## Application by The Drovers Solar Farm Limited for an Order Granting Development Consent for The Drovers Solar Farm

### The Examining Authority's (ExA) schedule of proposed changes to the applicant's draft Development Consent Order (dDCO) (Revision 04) [\[REP4-003\]](#)

Issued on: 29 September 2026

UK0037735.5772-DCOPans-0005

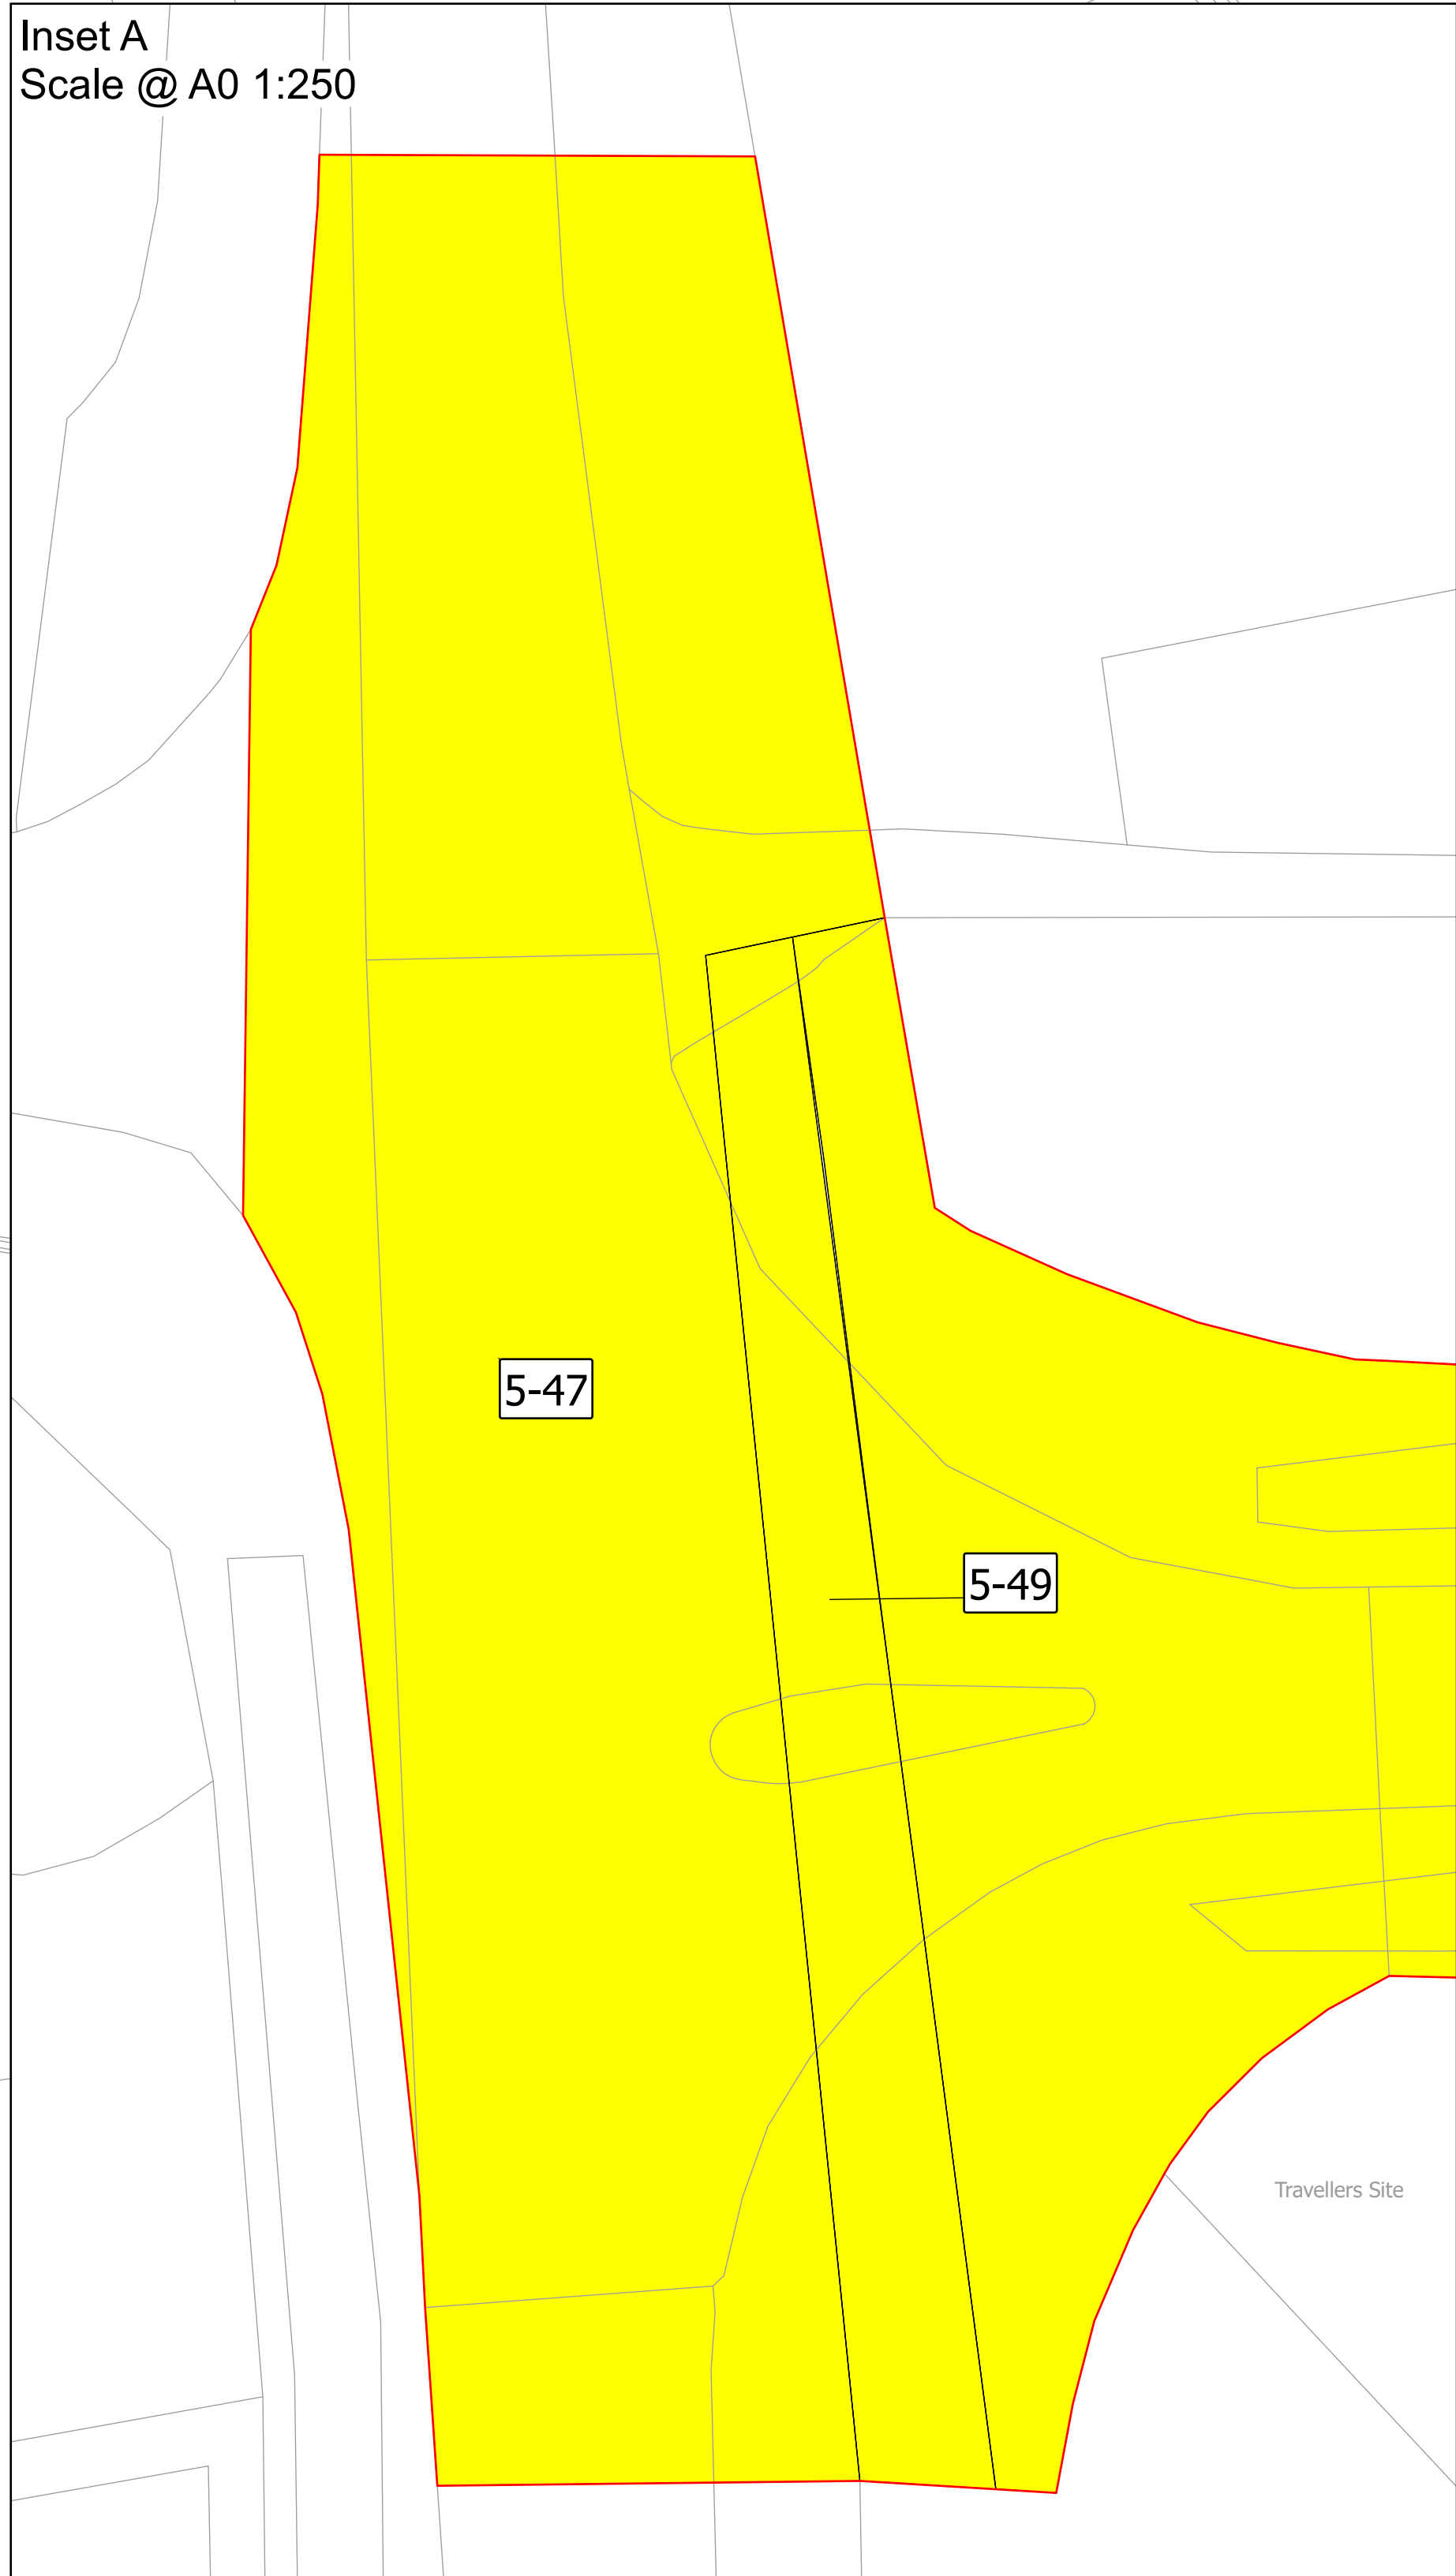
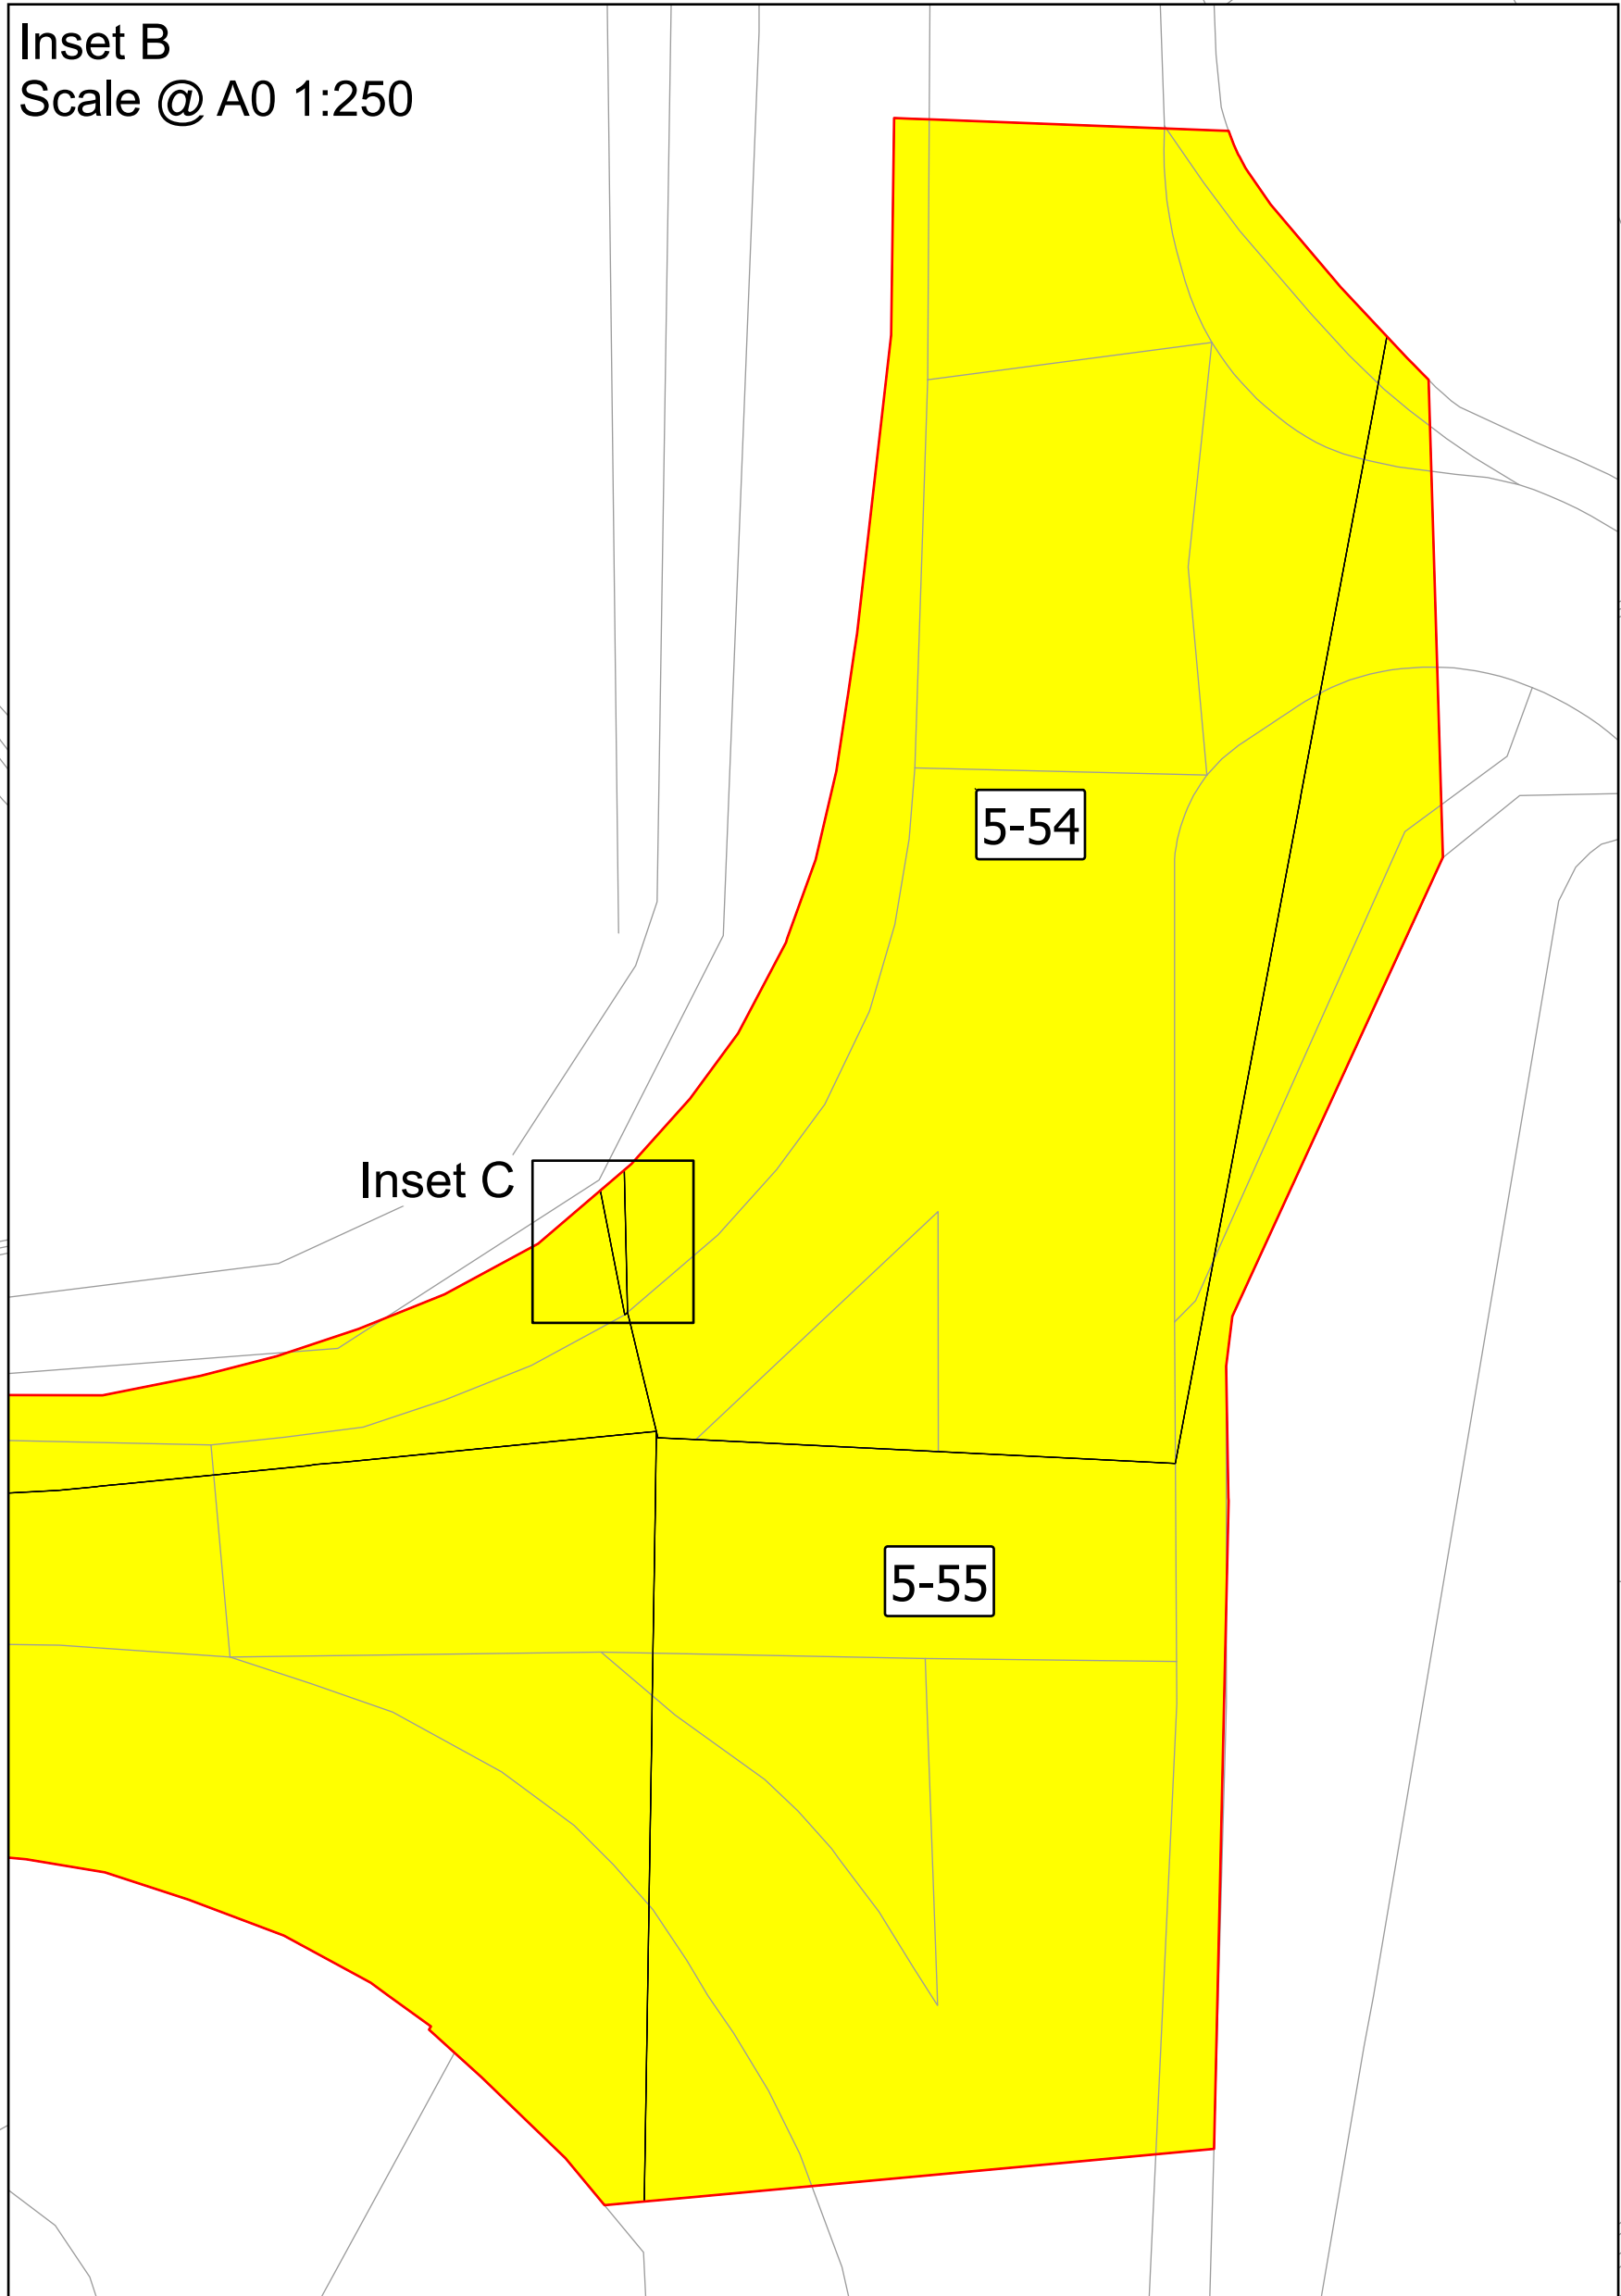
| Article/<br>Schedule                                                 | ExA's proposed changes<br>Deletions shown as strike through (for example)<br>Insertions shown in bold (for example)                                                                                                                                                                                                                                                                                                                                                                           | ExA's reasoning and comments                                                                                                                                                                             |
|----------------------------------------------------------------------|-----------------------------------------------------------------------------------------------------------------------------------------------------------------------------------------------------------------------------------------------------------------------------------------------------------------------------------------------------------------------------------------------------------------------------------------------------------------------------------------------|----------------------------------------------------------------------------------------------------------------------------------------------------------------------------------------------------------|
| Schedule 11                                                          | (1) Plot reference number shown on the Land Plan<br>1-08, 2-12, 2-33, 2-34, 2-35, 4-46, <del>5-47, 5-49,</del><br><del>5-50, 5-51, 5-53, 5-54, 5-55, 5-56</del>                                                                                                                                                                                                                                                                                                                               | In respect of each plot in the Book of Reference (5-47, 5-49, 5-50, 5-51, 5-53, 5-54, 5-55, 5-56) National Highways (NH) is identified as either a Category 1 person (as Owner/Occupier) or a Category 2 |

| Article/<br>Schedule                       | ExA's proposed changes<br>Deletions shown as strike through ( <del>for example</del> )<br>Insertions shown in bold ( <b>for example</b> ) | ExA's reasoning and comments                                                                                                                                                                                                                                                                                                                                                                                                                                                                                                                                                                                                                                                                                                                                                                                          |
|--------------------------------------------|-------------------------------------------------------------------------------------------------------------------------------------------|-----------------------------------------------------------------------------------------------------------------------------------------------------------------------------------------------------------------------------------------------------------------------------------------------------------------------------------------------------------------------------------------------------------------------------------------------------------------------------------------------------------------------------------------------------------------------------------------------------------------------------------------------------------------------------------------------------------------------------------------------------------------------------------------------------------------------|
|                                            |                                                                                                                                           | <p>person (holding rights granted by a Deed of Exchange dated 17 December 1984).</p> <p>The ExA is minded to agree with NH that the proposal to acquire temporary possession over NH's land does not accord with the Government guidance on the basis that it not necessary or proportionate for these powers to be included in the DCO when an alternative approach is available. The ExA agrees with NH that given the extent of the works proposed and given the availability of NH's normal process for enabling such works, there is no need for these works to be included in the DCO.</p> <p>Plots 5-47, 5-49, 5-50, 5-51, 5-53, 5-54, 5-55 and 5-56 should be removed from the Book of Reference, the Order Limits, and any other relevant application documents in which they are currently referred to.</p> |
